# Comments for Planning Application 22/05035/RECON

Application Number: 22/05035/RECON

Address: 2 Hayes Close Hayes Bromley BR2 7BZ

Proposal: Variation of condition 2 of permission 22/05035/FULL1 (granted for the demolition of the existing dwelling and erection of a 2 storey five bedroom detached dwellinghouse with associated refuse and parking provision) to allow minor material amendment to approved scheme comprising elevational alteration to the front of the dwelling/installation of additional glazing.

Loft Floor Plan | Proposed

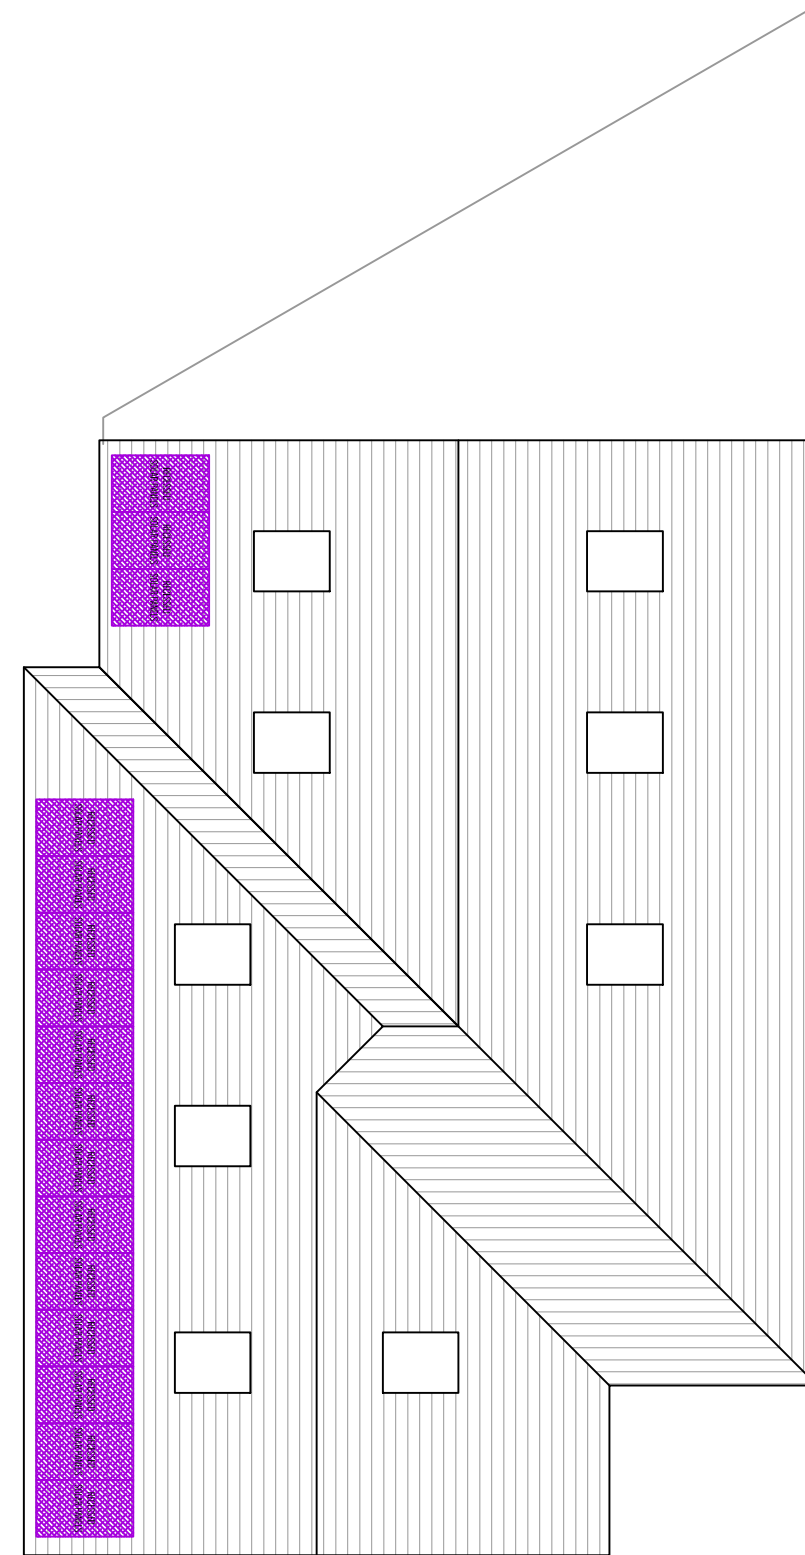
Comment: I am strongly objecting about the proposed very large window at the front of the house in the Proposed Loft Floor Plan and Roof Plan, which was added to the Bromley Planning Portal on 18th January 2024 (for which I did NOT receive any written/postal correspondence about).

The window DIRECTLY OVERLOOKS my back garden and creates a really major privacy issue. I have three young daughters and feel this new window is a violation of their privacy in particular - they have all already said they will feel uncomfortable playing, relaxing or sunbathing in the garden if the amendment to the plans to include this huge intrusive window was to be permitted. It would materially impact my family, their way of living and most significantly and importantly their MENTAL HEALTH.
